From: Carmichael Ian [mailto:Ian.Carmichael@thamesvalley.pnn.police.uk]
Sent: 12 July 2019 09:16
To: Caroline Ford
Cc: Planning
Subject: Planning ref: 19/01036/F. Bicester Eco Town Exemplar Site Phase 2 Charlotte Avenue Bicester.

Planning ref: 19/01036/F. Bicester Eco Town Exemplar Site Phase 2 Charlotte Avenue Bicester.

Thank you for consulting me on the planning application above. I have analysed crime data, reviewed the submitted documents and visited the site.

1 West Elevation - River Corridor
1 : 200

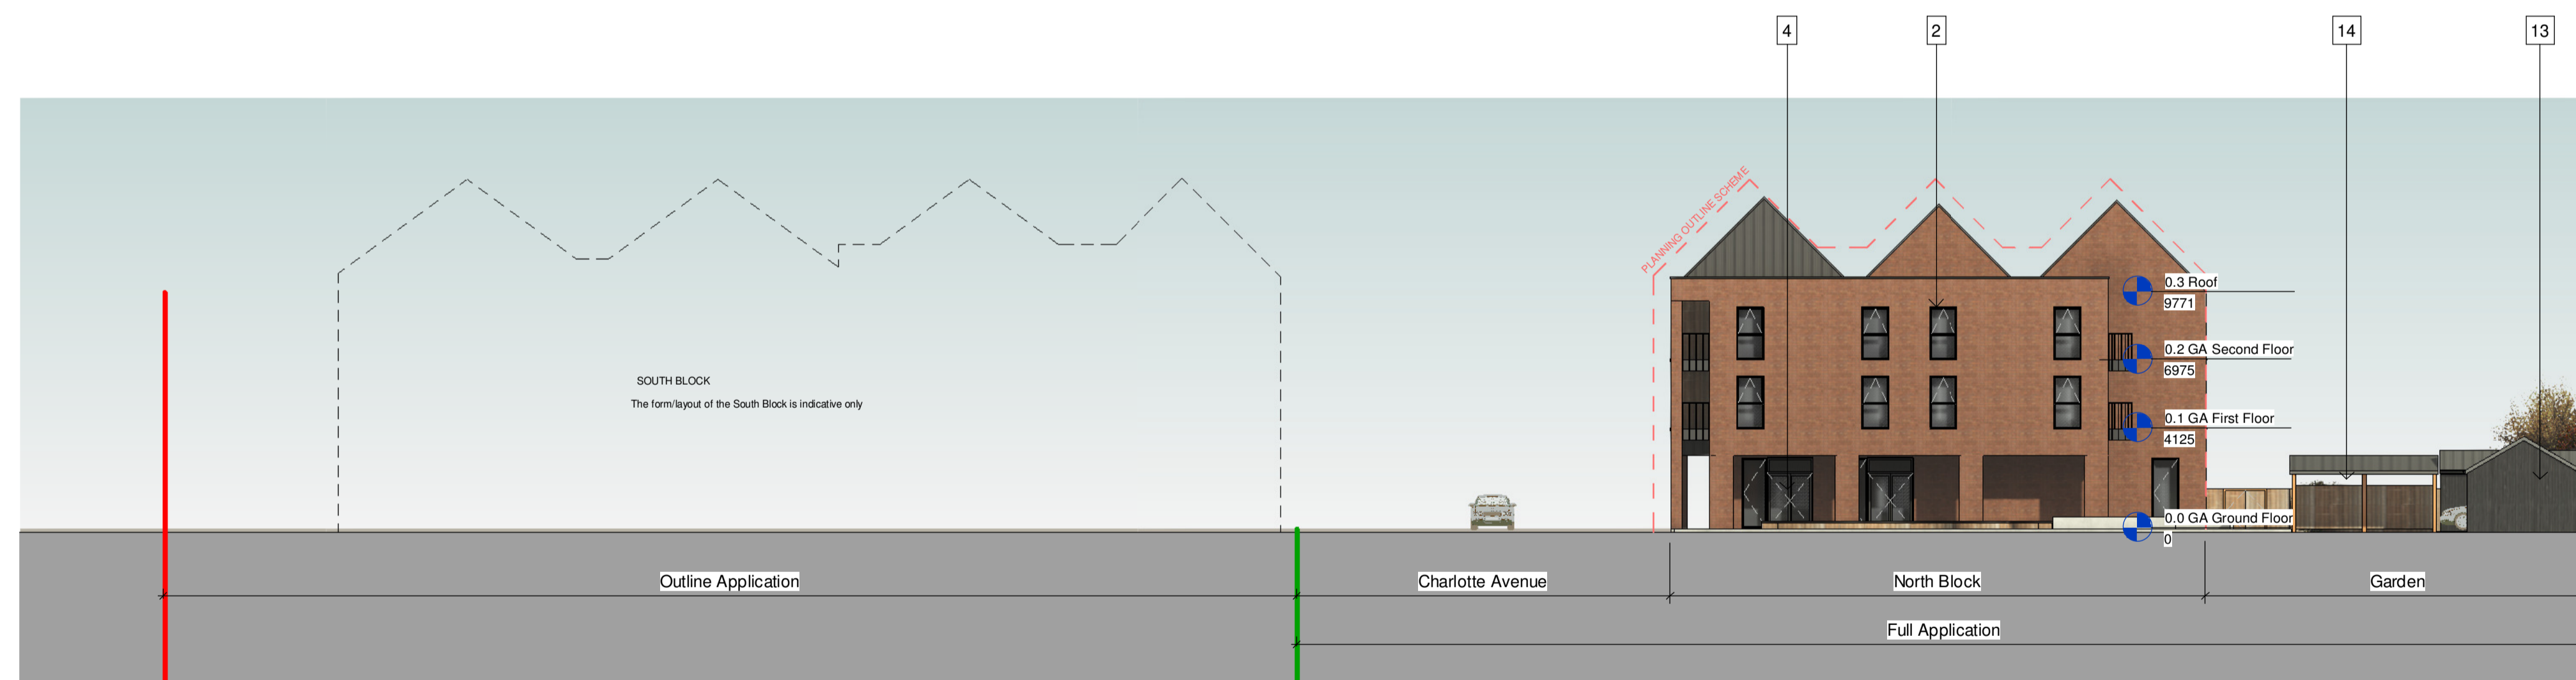
- There are sections of colonnades on some elevations of both blocks. These must be lit independently from above as relying on street lighting to illuminate the undercrofts could create dark hiding places that assist criminal and/or anti-social behaviour.
